Planning Application: Seeking advice on an **OUTLINE** planning application for this site for 175 residential units

Reference: A/99/17/OUT (3) **Current Comments in red typeface**

Location: Land south of Water Lane, `

Consultant Arboriculturist

Tree Protection Plan

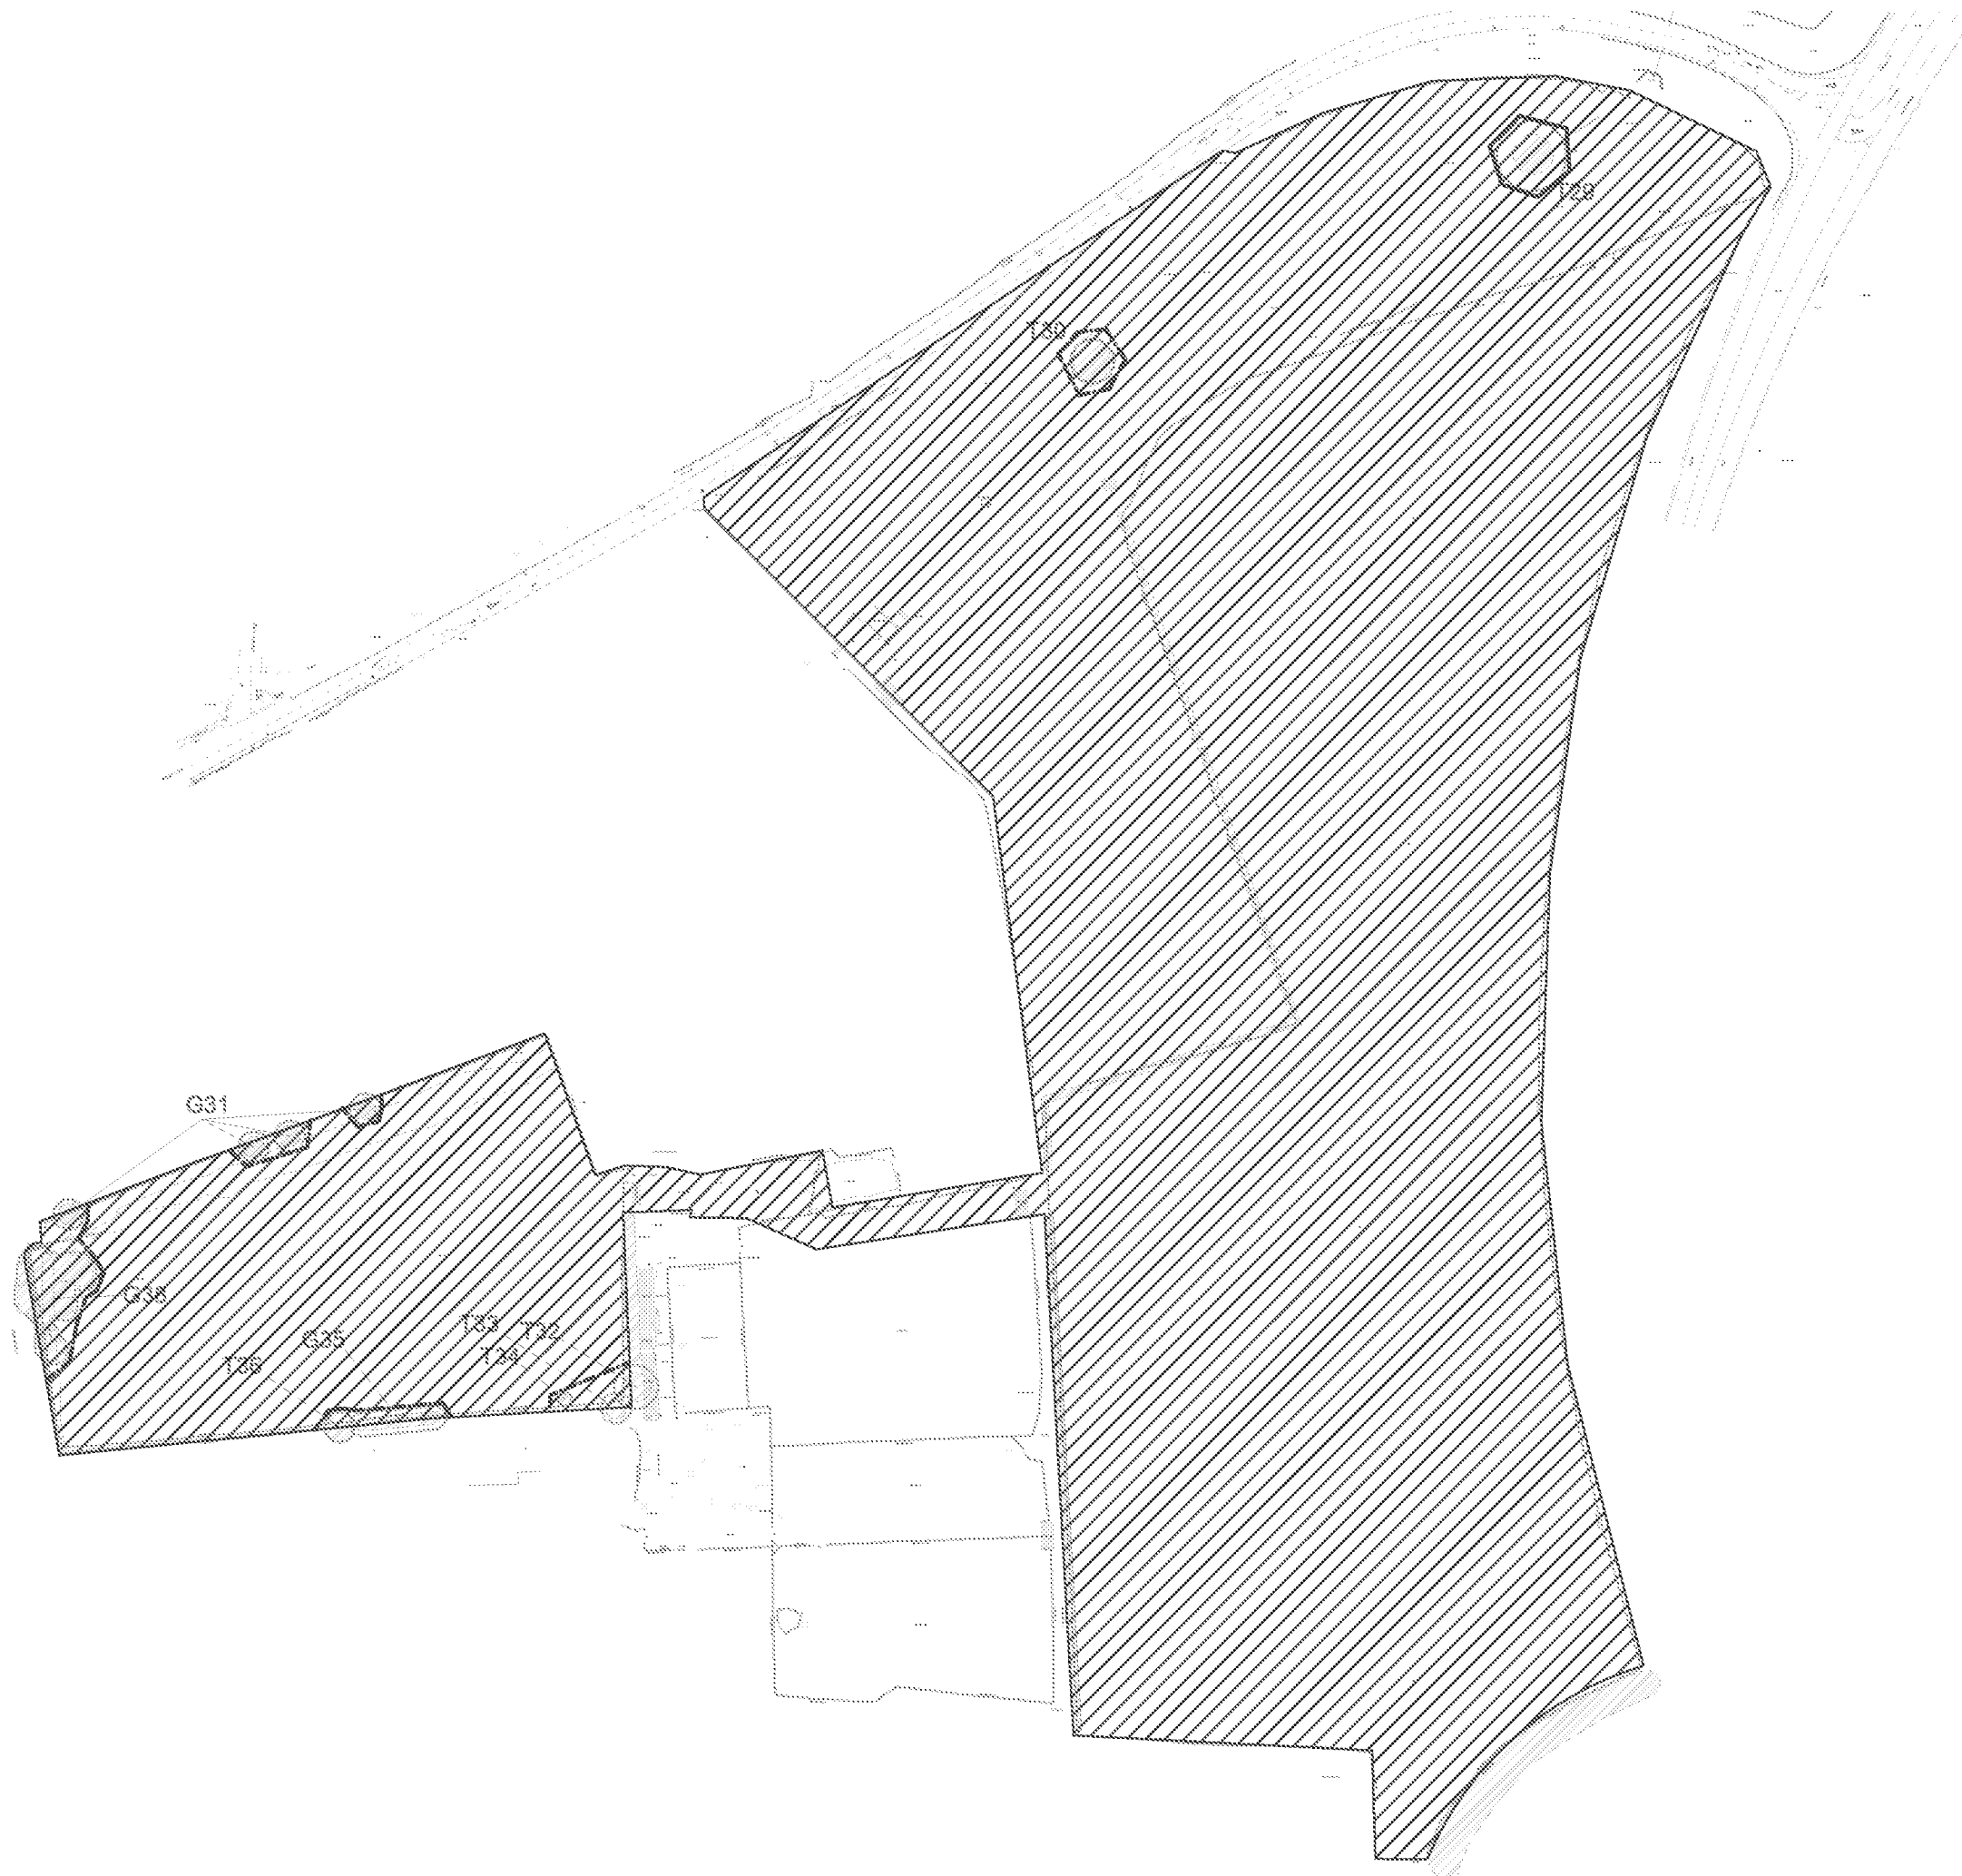
- However, despite there being an Illustrative Masterplan 1911/PO3 Rev E in existence in June 2016 the AMS report does not reference this document and is very generic in nature and furthermore the Tree Protection Plan is not acceptable because it has to be drawn onto the masterplan base so that I can assess the true impact that it will have on the retained trees – instead it is drawn onto the red line site boundary drawing.

- **The current Tree Protection Plan has now been drawn onto a version of the Masterplan but unfortunately the one they have chosen to use is not up to date and the revisions to the layout are not shown on it so I cannot accept this for assessment. I also question the validity of preparing a very detailed Tree Protection Plan for an outline application – inappropriate in my view as it should only come in to accompany a detailed layout at a later date.**

- **Having discussed this matter with a representative of PJC it was agreed that at this juncture they only supply an AIA report & Tree Constraints Plan and that an AMS & TP Plan should accompany the detailed layout at a later date.**
